Application No: AW/1/25/HH
Site Address: 27 Aldwick Avenue Aldwick PO21 3AQ
Description of works: Part single, part two storey side and rear extensions, conversion of garage to habitable use, hip to mansard roof extension with dormers, and alterations to fenestrations.

Thank you for your internet representation made on 5th February 2025 which has been recorded as an objection with the comments as follows:

Proposed parking

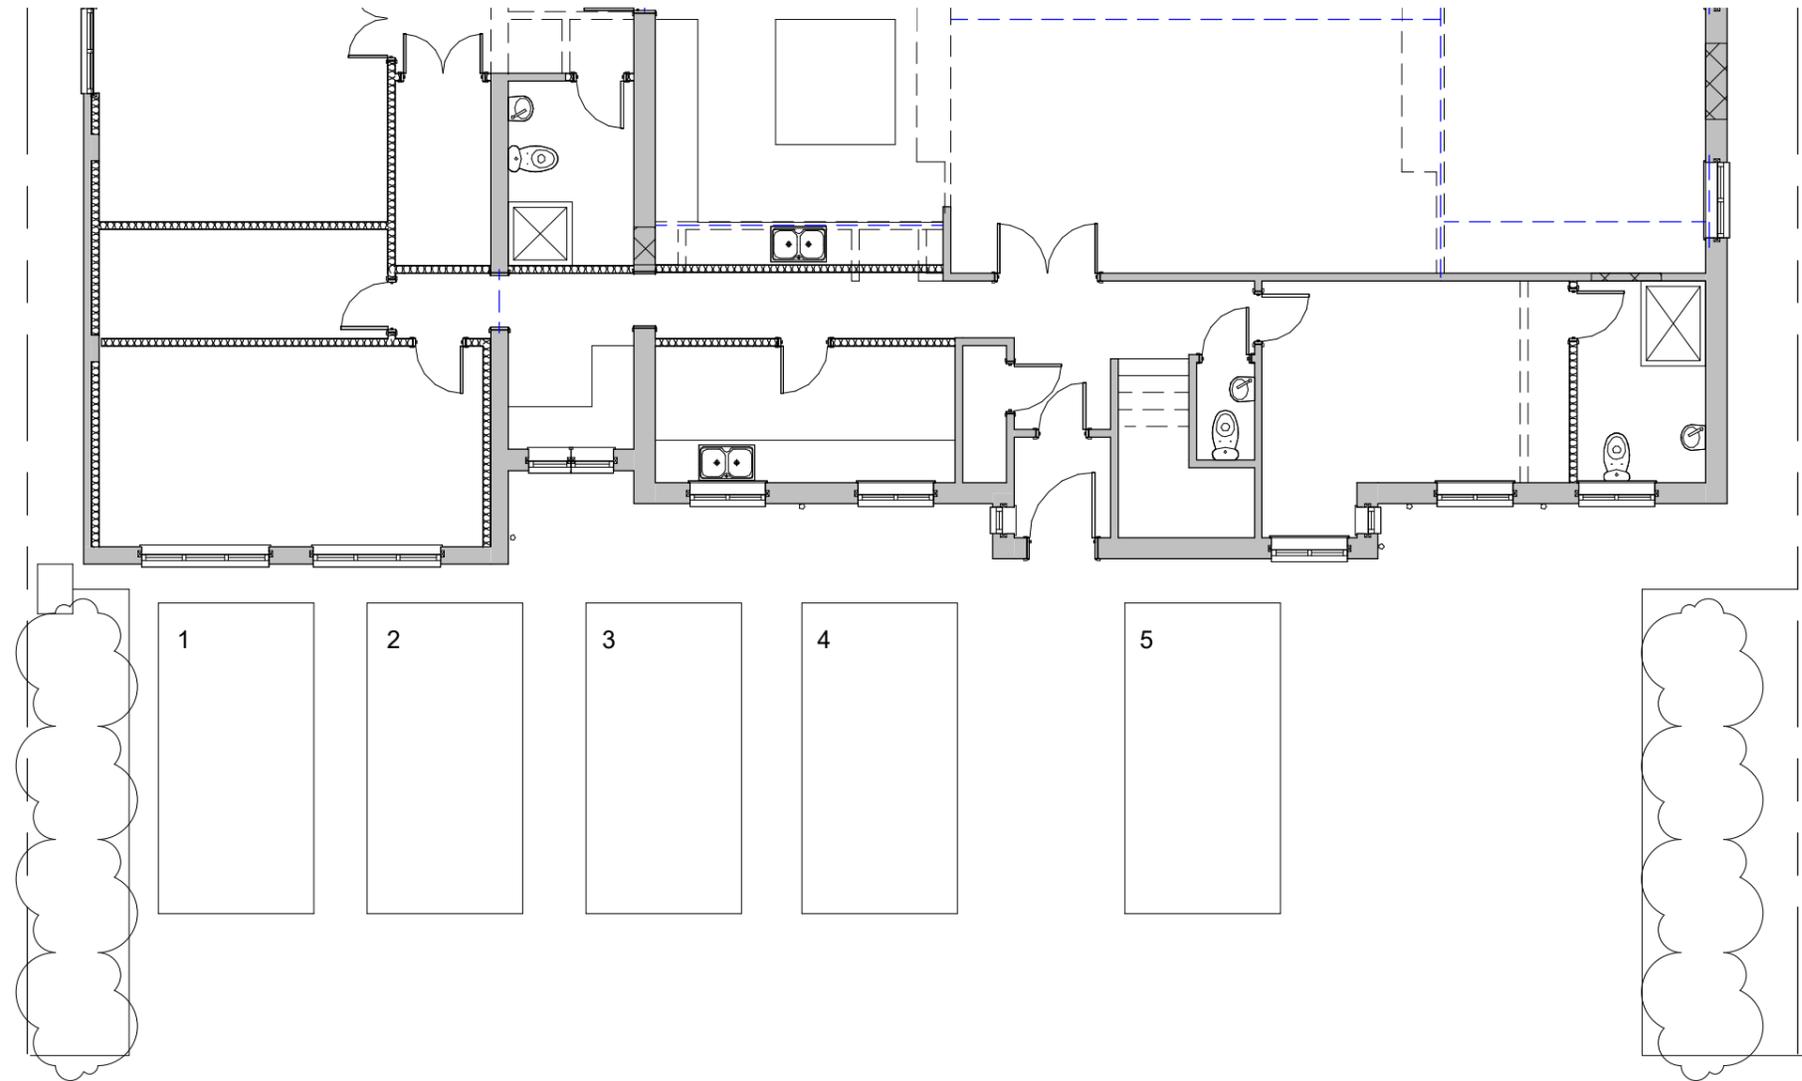
The plans submitted reduce the amount of off-road parking for the property whilst increasing the possible number of occupants. Aldwick Avenue is already congested with on road parking, especially where there are often children playing on the verges. The addition of extra vehicles on the road will make this more hazardous.
